RE: Port City Glass Permit Application; 50 India Street, Portland, ME (28-P-15)
DSC Project No. 2012-141

At your request, Downeast Structural Consultants, LLC performed a Limited Structural review of the Dormer Roof Framing at the Port City Glass Building located at 50 India Street in Portland, Maine on December 3, 2012. This report has been prepared based on that review.

Our review is limited to the existing ten small framed roof dormers and construction documents provided by Luckse Design, LLC dated December 20, 2012 with sheets S-1 through S-4. The review excludes concealed structural systems associated with the overall building and all other floor framing areas.

Drawing Number **S-1**

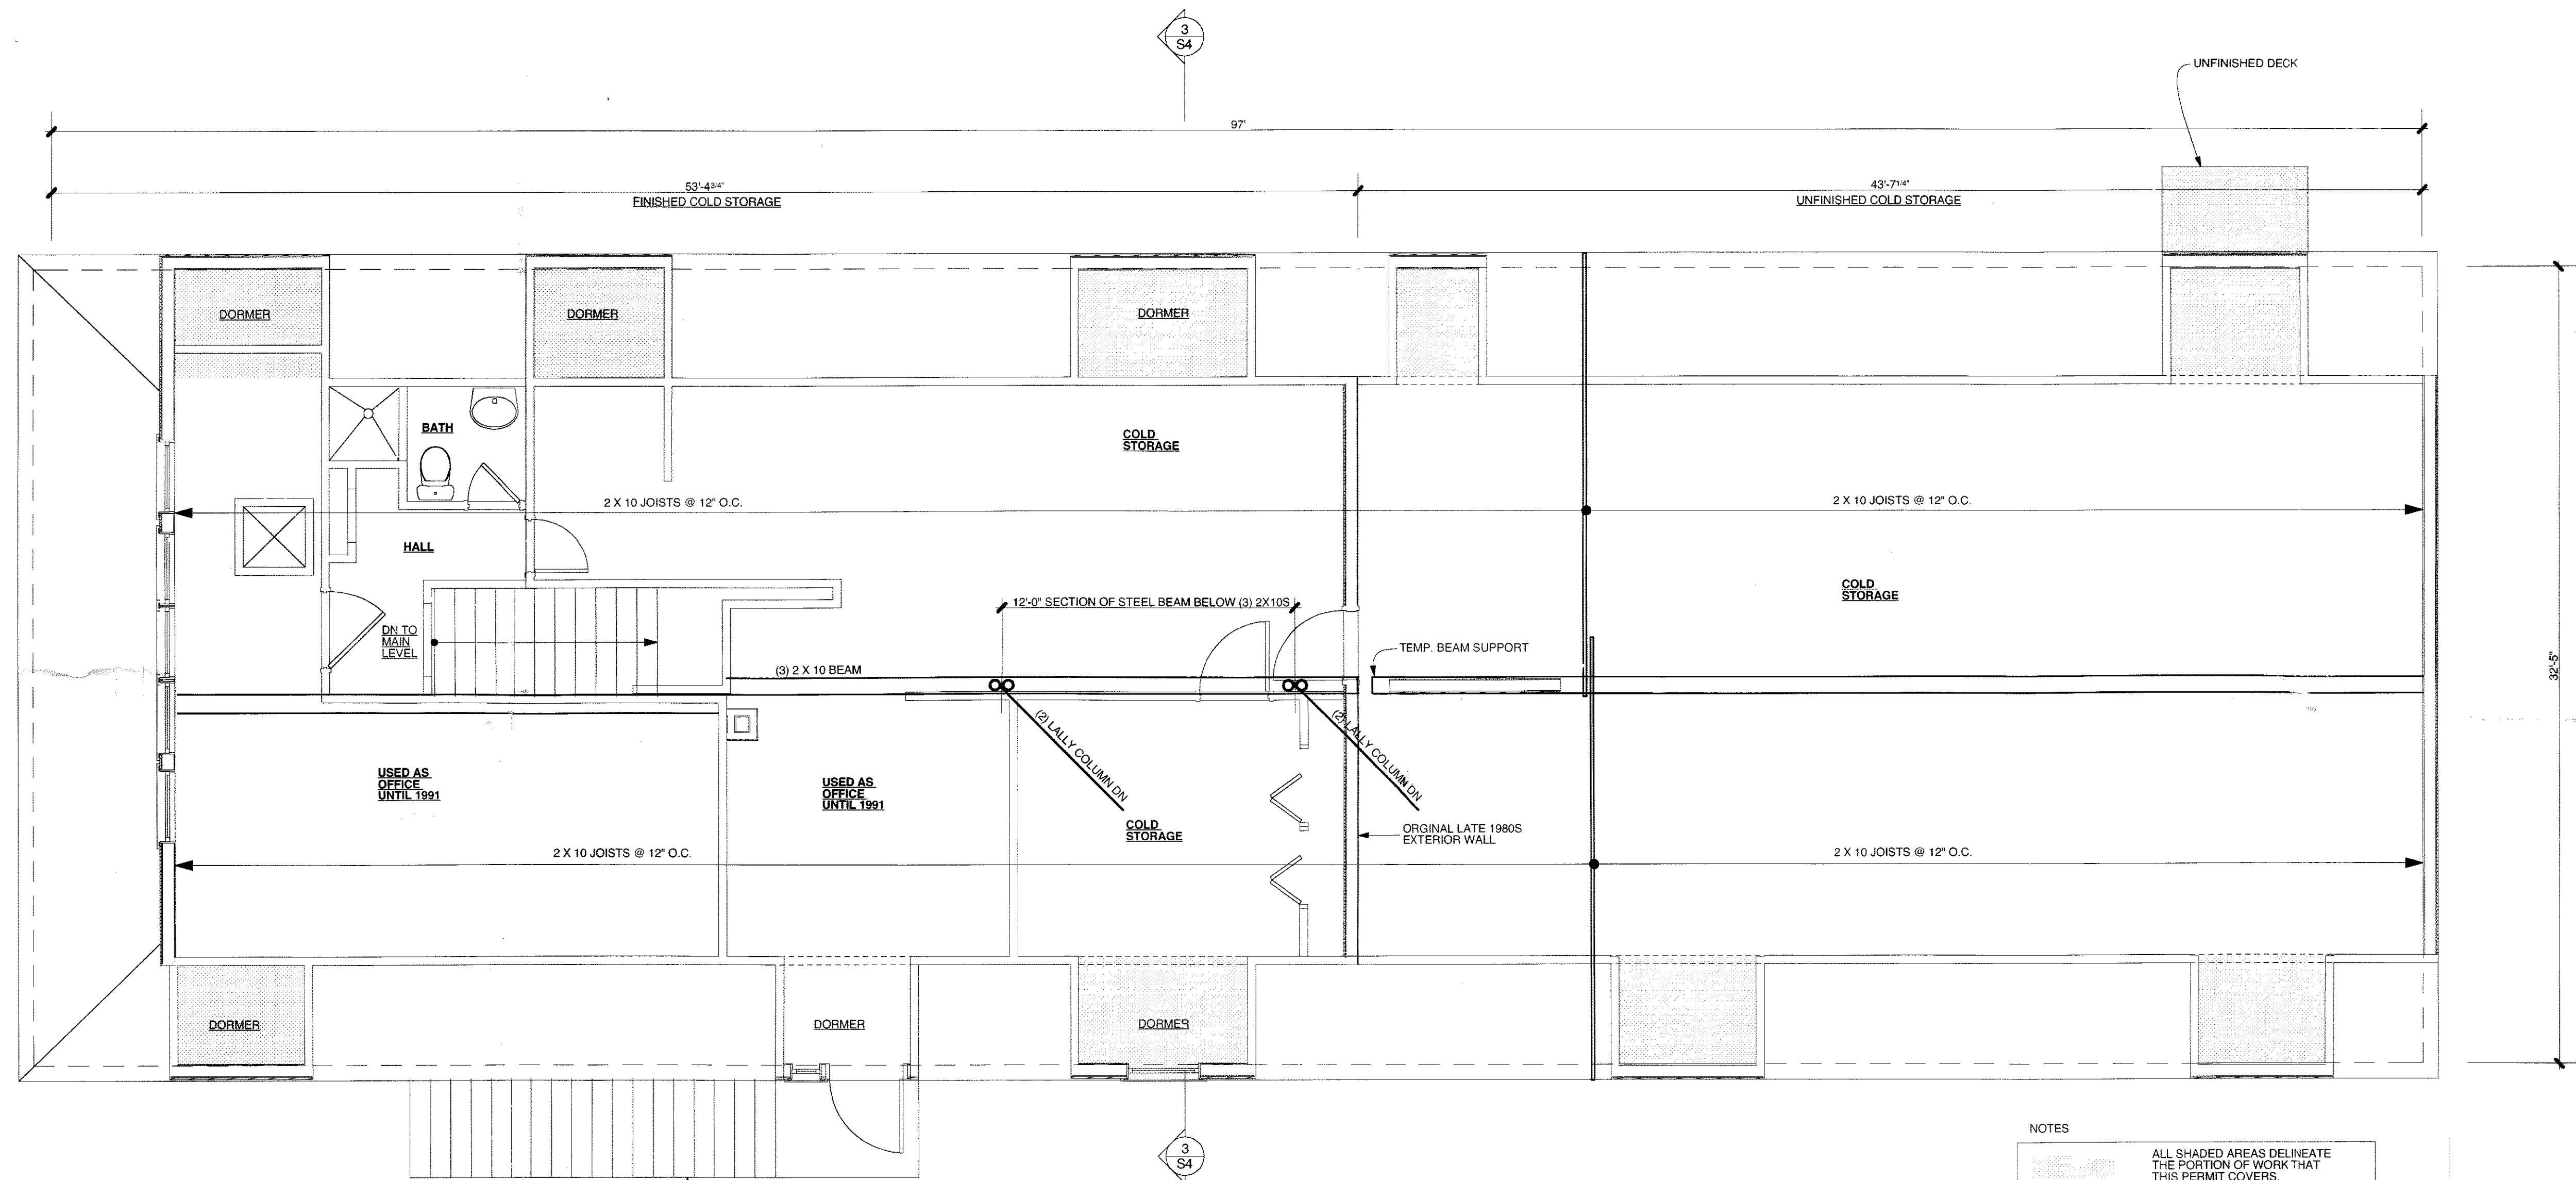
Following our review of the framing tributary to the steel beam located at the rear of the building we recommend additional permanent columns be installed. Based on an occupancy of "Uninhabitable Attic Space" at the Cold Storage Area along the second floor we recommend additional columns be placed at third-points along the beam length. The columns shall be either 8x8 wood composite or structural steel framing members. The columns shall bear on 1/2-inch steel plates bolted to 2'-6" square by 1'-0" deep reinforced concrete footings.

1. *We recommend removal of the wood balcony at the rear of the building (Refer to Photo 4).*
2. *Provide (2) 8x8 Composite Wood or Steel Columns at Garage Bay/Workshop Area at Third-Points along existing steel beam length. Provide column cap connection to existing steel beam above and column base connection to 1/2-inch steel plate below.*

4 TYPICAL DORMER SECTION
SCALE: 1/2" = 1' - 0"

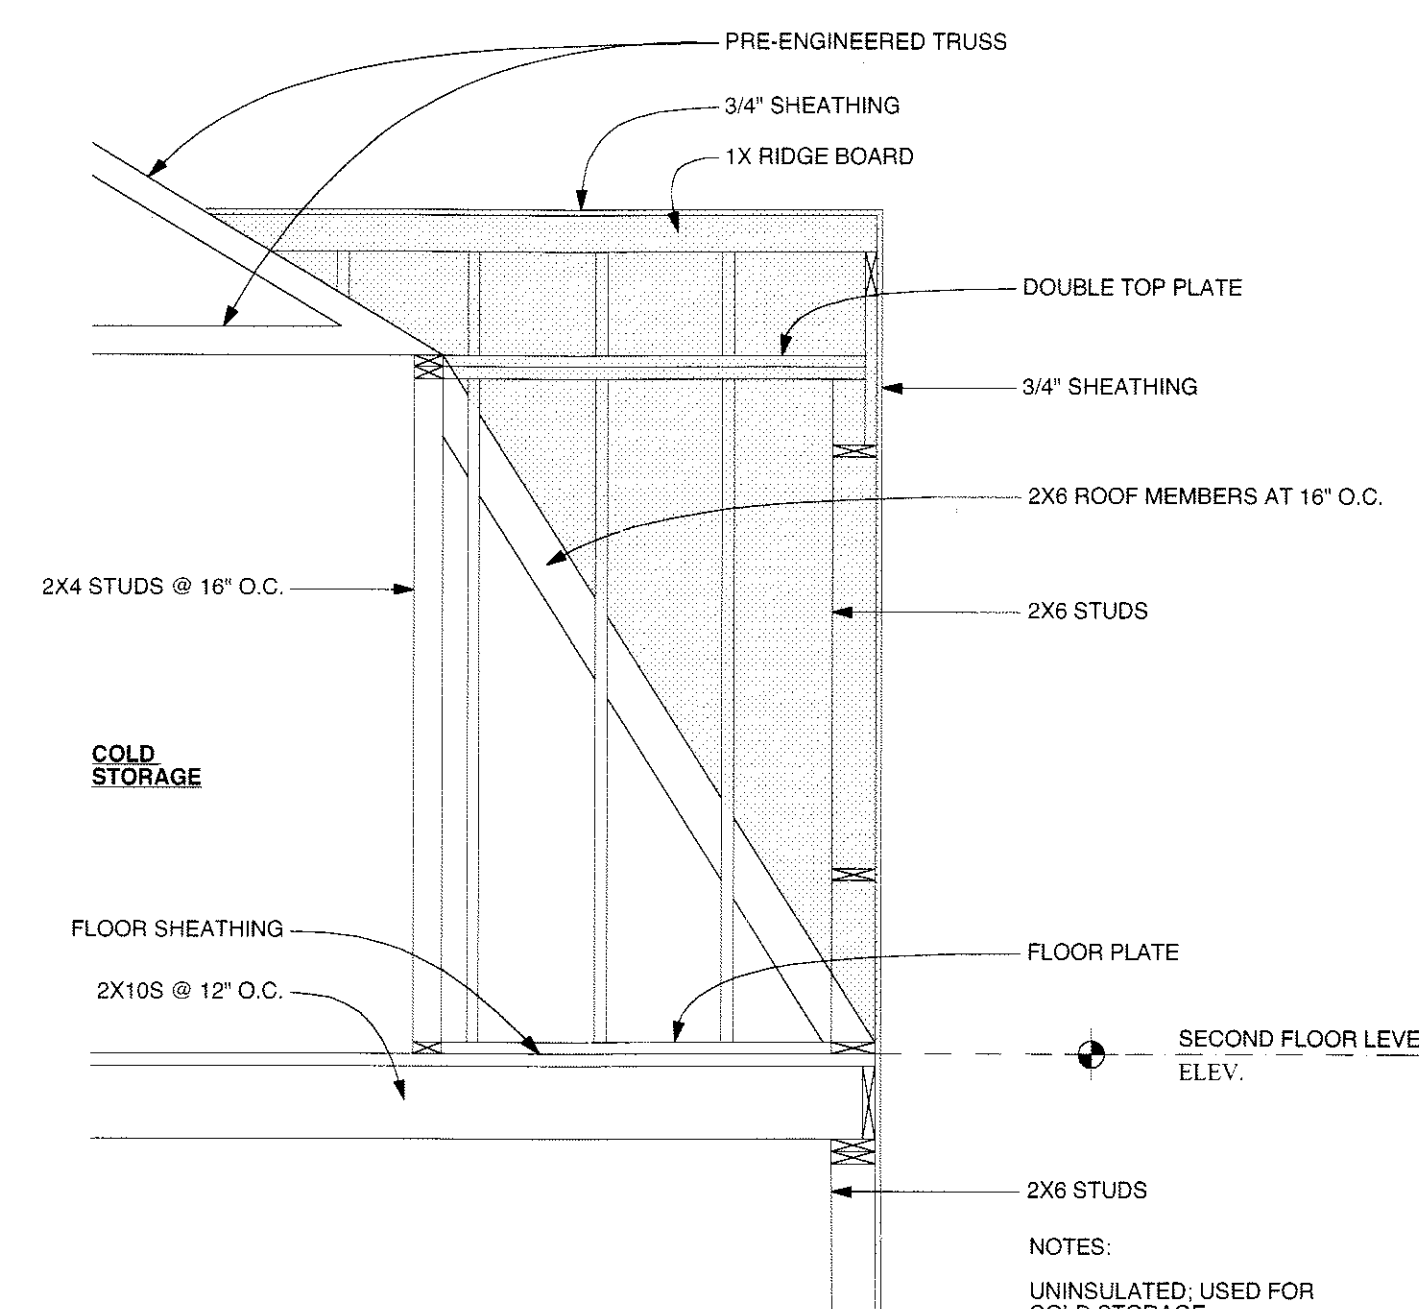
1. At the time of our site visit ten small roof dormers were previously constructed into the existing roof system of the Port City Glass Building. The dormers are approximately 8-feet by 5-feet and are equally spaced along each side of the building (Refer to Photo 2).
2. The dormers are constructed of 2x dimensional lumber and supported on interior and exterior load bearing walls (Refer to construction documents provided by Luckse Design, LLC dated December 20, 2012 with sheets S-1 through S-4).
3. An unfinished balcony is located along the rear of the building.
4. While on the first floor at the rear of the building we observed a steel beam spanning between the Workshop/Garage Bay and the Storage Area. The steel beam spans approximately 42-feet and supports the second floor joist framing. The beam is only supported at each end.

Based on our review, the dormers appear adequately constructed and do not adversely affect the roof framing or adversely affect the overall structural integrity of the building.
